Recommendation Report for Works to Tree(s) on trees subject to a Tree Preservation Order (TPO)

REF NO: AW/107/21/T

LOCATION: 49 Chawkmare Coppice
Aldwick
PO21 3SP

PROPOSAL: Mature Monterey Pine (T1) - Canopy reduction of up to 15% to removed dying branches.

Monterey Pine in rear garden of No. 49.
Chawkmere Coppice - P021 3SP

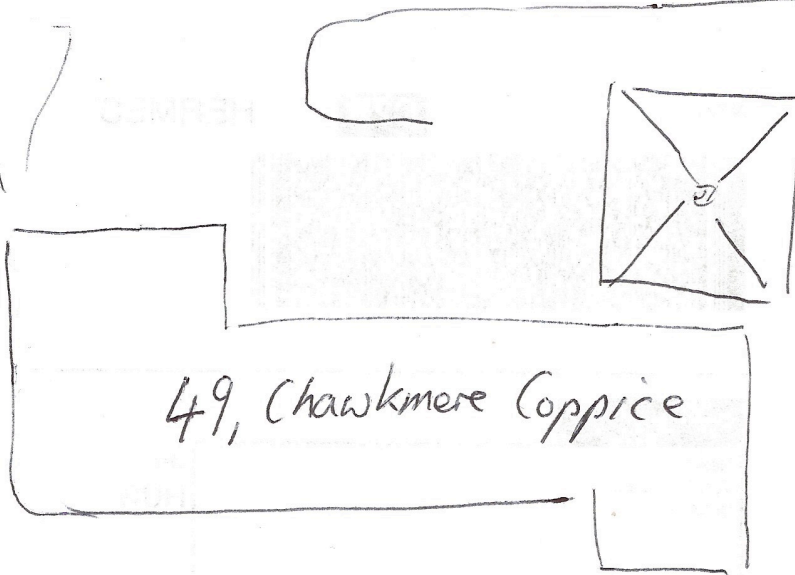
Outwardly and from distance (roadside) this tree appears to be in a fair physiological state (and assumed

to be so in the absence of any information/evidence provided to the contrary). It is a large and prominent tree, of obvious public amenity and landscape value.

The applicant employed Arun Tree Company Ltd to assess the tree and they have not reported any obvious structural defect or disease, other than the presence of dying branches throughout the crown. The presence of deadwood and declining branches may be characteristic of perfectly healthy trees of this type or associated with a pathogen and/or environmental factor.

Whilst an understanding of the work proposal has been reached, following correspondence between planning department and applicant; for the benefit of all interested parties, it should be acknowledged that the 'Description of works' is open to interpretation. The intention is clearly to undertake a canopy thin (maximum 15% of current volume removed) rather than a canopy reduction (where typically the height and spread of the tree are reduced). The latter operation being entirely inappropriate.

The principle of the work proposal is sound and for many trees in similar locations would be supportable. It would be intensely onerous and perhaps impractical to comprehensively specify, consequently we have only a statement of intent. Should we approve such an application, we would cede control over the operation (extent and location of crown material removed) to the applicant and their appointed contractor. That is not a satisfactory position for the local planning authority to be in, where the tree is of such high value.

- 1 The term 'dying branches' - especially in relation to Pine (and most needle-bearing conifers) is an unsatisfactory work specification. This is because those types of tree (even when in excellent health) will possess a number of 'slow declining' branches, characterised by a progressive thinning of foliage and increase in dead tertiary branches and twigs. Those declining branches still have an important function in maintaining vitality of the whole tree, as younger (superseding) branches develop higher in the crown. Granting approval for this application would permit any contractor undertaking the work to remove those important branches causing harm to the tree.

I recommend REFUSAL for this application.
